Date: 18.12.20

Re: Section 5 Declaration on whether the conversion of the ground floor retail unit at No. 45 Ferrybank, Arklow, Co Wicklow to 1 No. Apartment is or is not development and is or is not exempted development.

Wicklow Co Council Exemption Ref: 68/2020

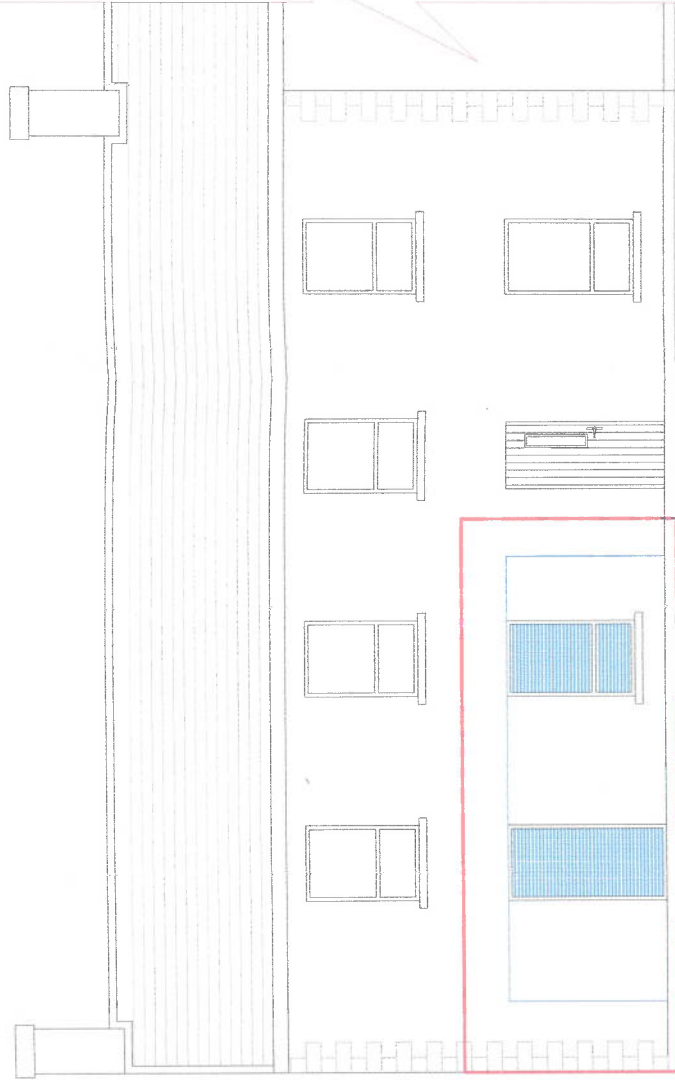
Under Exemption application 68/2020, the planner deemed that *“the provision of an external wall and railing would it is considered materially affect the external appearance which would make it inconsistent with the character of the structure, and of the structure on the opposite side of the junction to the north”*

- The provision of external wall and railing would it is considered materially affect the external appearance which would make it inconsistent with the character of the structure, and of the structure on the opposite side of the junction to the north.

- The proposed works to the elevations and in particular the shopfront is consistent with the fenestration details and architectural character of the existing structure and streetscape.
- In relation to the proposed front boundary wall and railing, it is proposed to erect a wall and railing to the same design and standard as the adjoining property at No 46 & 48 Ferrybank.

- Please note that the proposed wall and railing enclosure to the front of the subject property is consistent with No 46 & 48 Ferrybank directly to the south of the subject property.
- Please note that the planner comments that it is inconsistent with the structure to the north on the opposite side of the junction is not comparable as there is a road junction separating them so there is no continuity to the streetscape at this location. It should also be noted that the planning status and history of the buildings to the immediate north of the subject site is not helpful for comparing planning standard precedence.
- Please see the attached land registry map highlighting in green that the majority of residential properties on Ferrybank from the Wheelie Pump corner to Stringer’s Lane all have enclosed front gardens with wall and railing boundaries. All the houses to the west

- The additional information above clearly shows that the provision of an external wall and railing would **NOT** materially affect the external appearance of the subject site and is wholly consistent with the character of the as-built environment along the entirety of Ferrybank.

➤ The proposed front wall is to be constructed in accordance with the building line of the adjoining property at No 46 Ferrybank and so does not bring forward the wall beyond the front wall of the neighbouring building. The building line of the 44 Ferrybank cannot be considered as there is a road junction between the properties and a discontinuity in the streetscape.

Ground Floor Plan

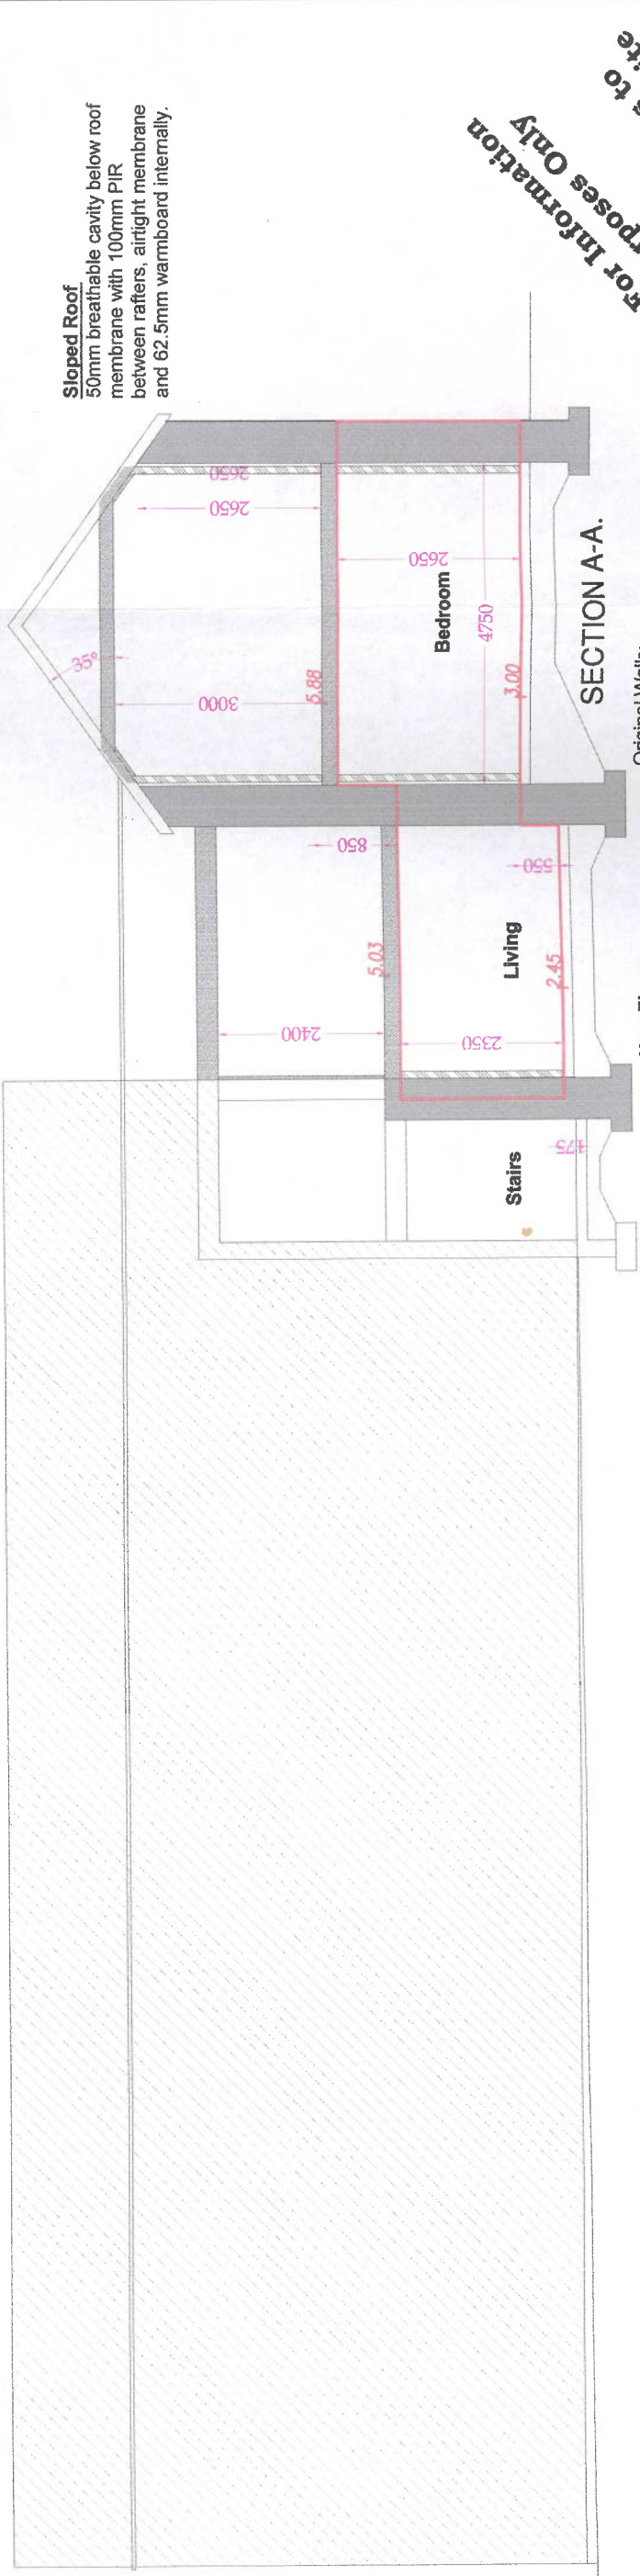
- (iii) The erection of a new wall and railing to the front of No 45 Ferrybank would be contrary to the restriction set out under Article 9 (iv) of the Planning & Development Regulations 2001 (as amended) as it would result in *"the construction, erection, extension or renewal of a building on any street so as to*

bring forward the building, or any part of the building, beyond the front wall of the building on either side"

➤ The works above refers to the construction of a building or extension. The proposal is for a minor wall and railing to the same standard and building line of the as built wall to the adjoining property.
